Land at New Road, Rustington

**SAFETY AUDIT EXCEPTION REPORT
FOR DEVELOPER PROMOTED SCHEMES**

Safety Audit Ref: RSA-16-069-L001

Planning or PSI Ref: A/11/17

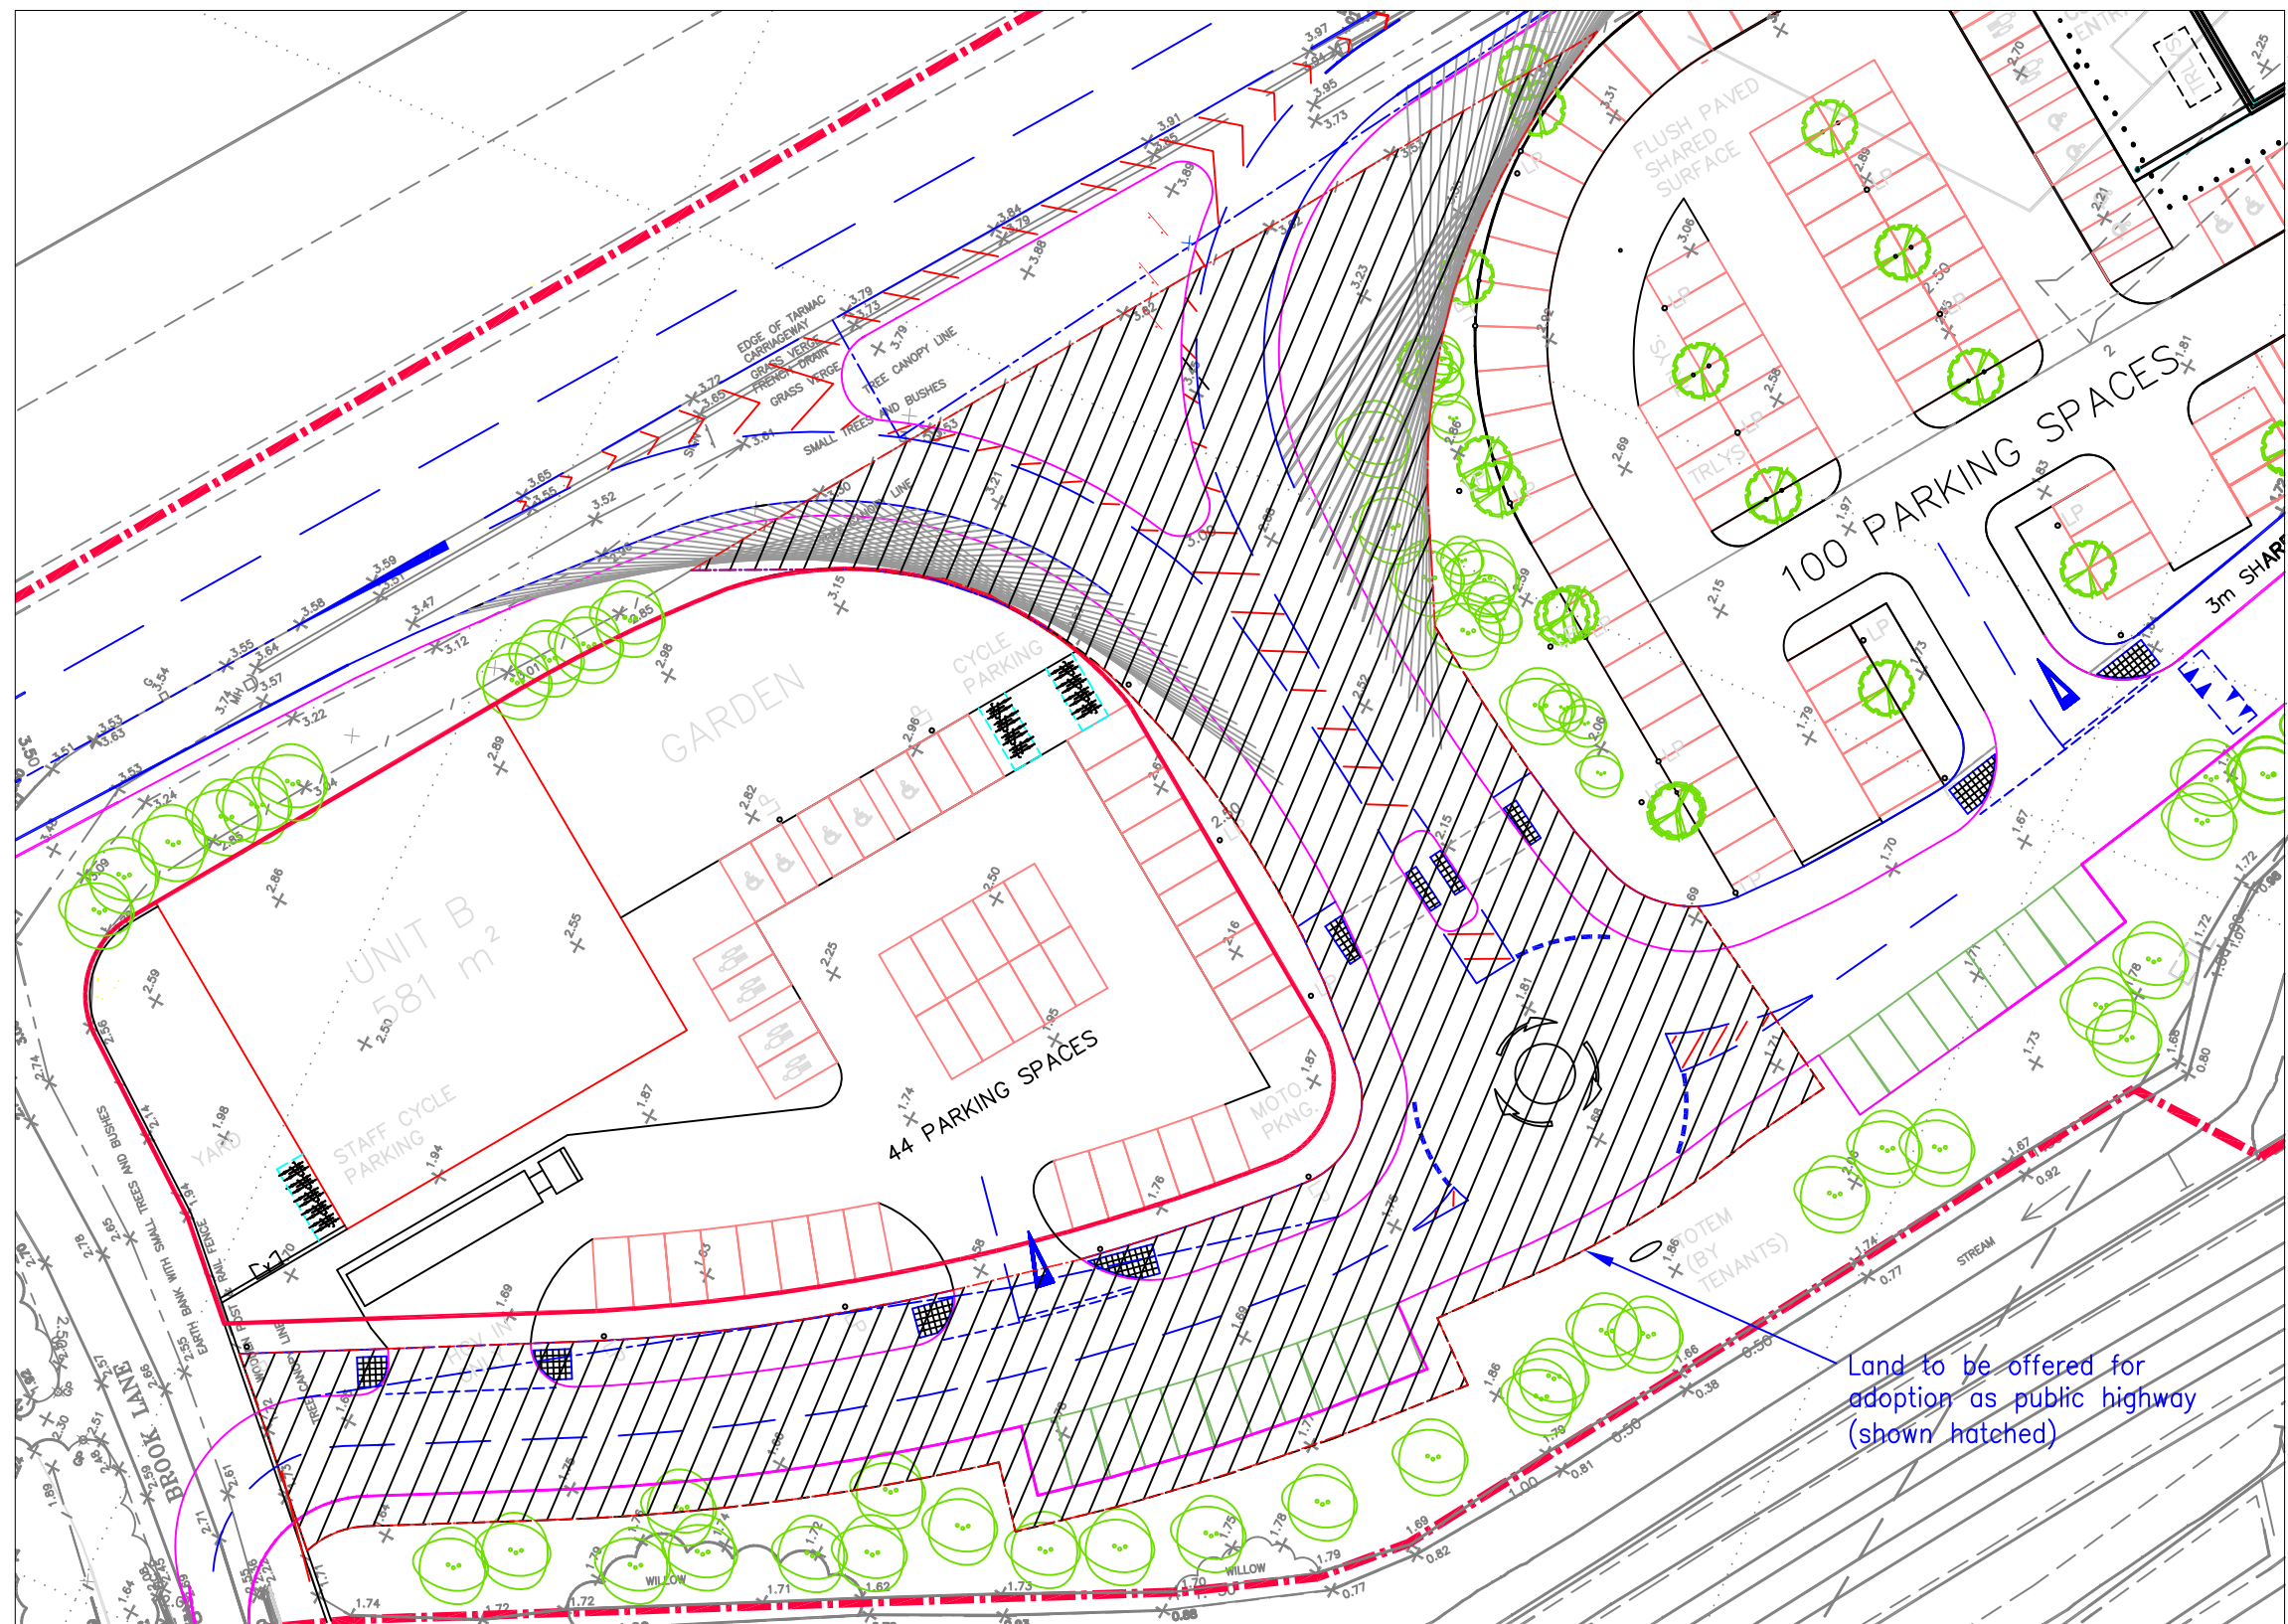
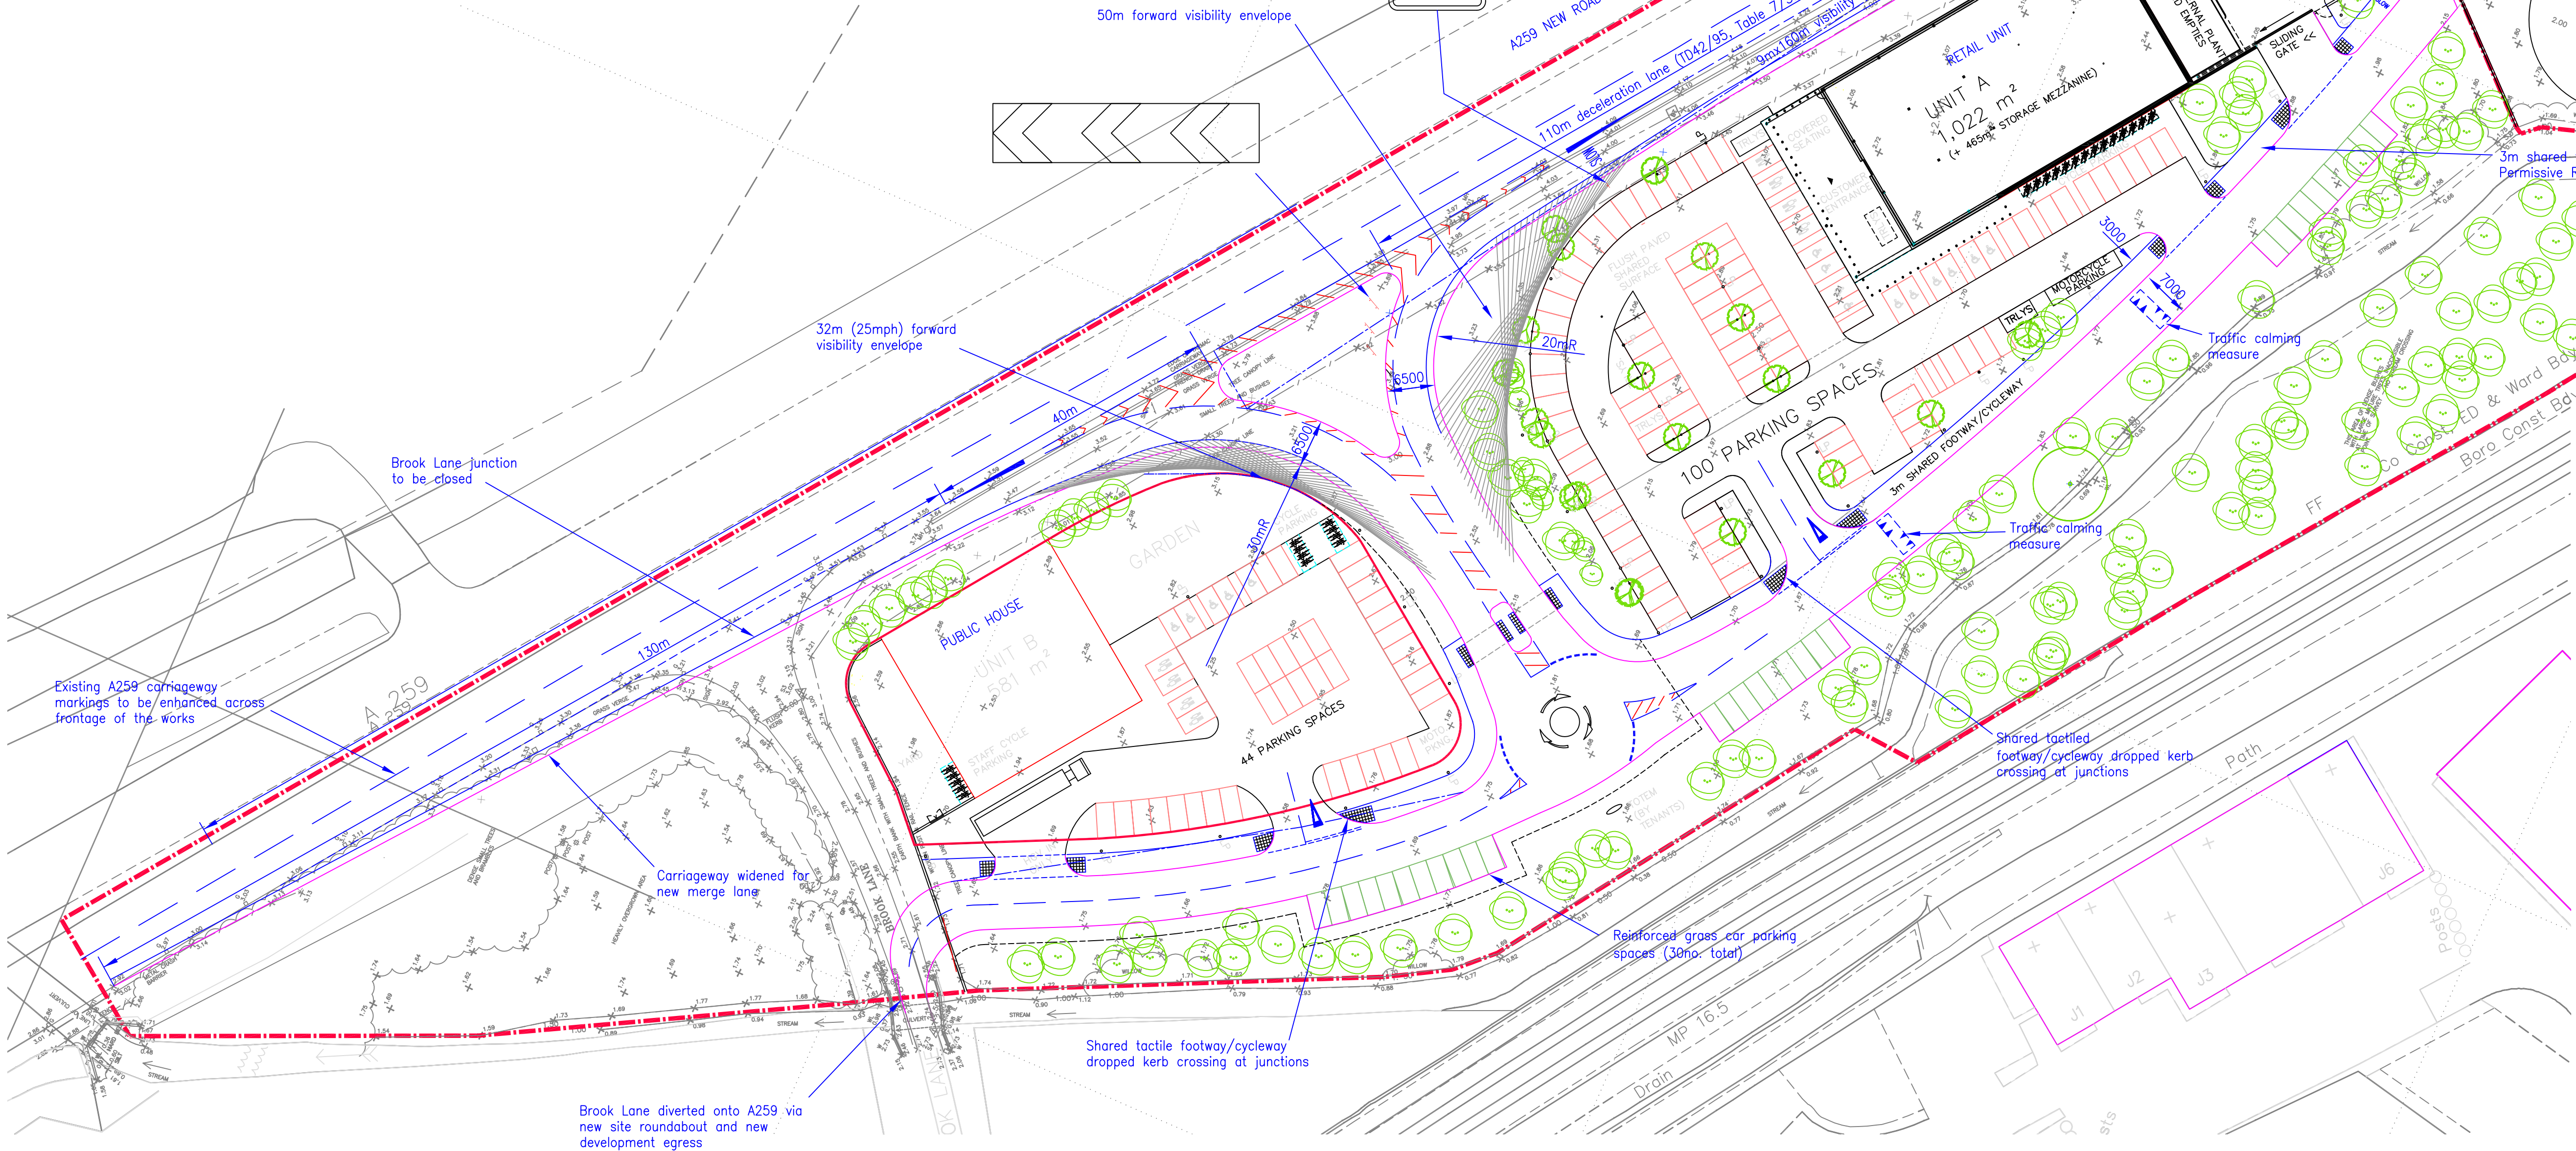
Para. No.	Problem (as identified by Safety Auditor)	Recommendations (made by Safety Auditor)	Designer's Response	Proposals
1.1	It was apparent from the site visit that the recently constructed acceleration lane associated with the adjacent development to the east, merges with the A259 channel line approximately 40 metres to the east of the proposed deceleration lane. Therefore vehicles exiting the adjacent development will be in conflict with vehicles entering the proposed development which are likely to be changing lanes simultaneously. This may result in side swipes and shunts along the recently constructed acceleration lane where vehicles are not able to merge onto the A259 from the adjacent development.	It is recommended that the increased weaving length is increased appropriately.	Traffic leaving the adjacent development will have to give way to traffic travelling along the nearside lane of the A259. Due to site constraints, the entry radius to the site is restricted to 20 metres. Figure 7/12 of TD42/95 shows the required length of the deceleration lane as dimension a. At the end of the deceleration lane Figure 7/12 indicates a give way triangle indicating that the entry radius into the site is not a speed reducing feature as the radius is beyond the give way lines.	There is no recognised standard for weaving length at an at-grade junction. The use of the grade separated standards are not considered appropriate, since there is no grade separation. The weaving length has been increased to 90 metres. The deceleration length has been amended to accord with a required distance 'a' of 110 metres for a design speed of 120kph, as specific in Table 7/5b of TD42/95. Additional SLOW road markings and advanced mini roundabout warning signs are retained in the design to warn approaching motorists of the on-site roundabout. The inclusion of advanced direction signs are proposed for Problem A5/2 will mitigate 'side swipe' concerns as motorists will be made aware of the location of both access and will be able to manoeuvre to the nearside land at the appropriate time in advance of the proposed access. The inclusion of an auxiliary lane rather than a taper lane will avoid the need for motorists entering the site to decelerate on the A259 itself and will address concerns regarding rear-end shunts from motorists leaving the adjacent site, as advised in para 7.56 of TD42/95.
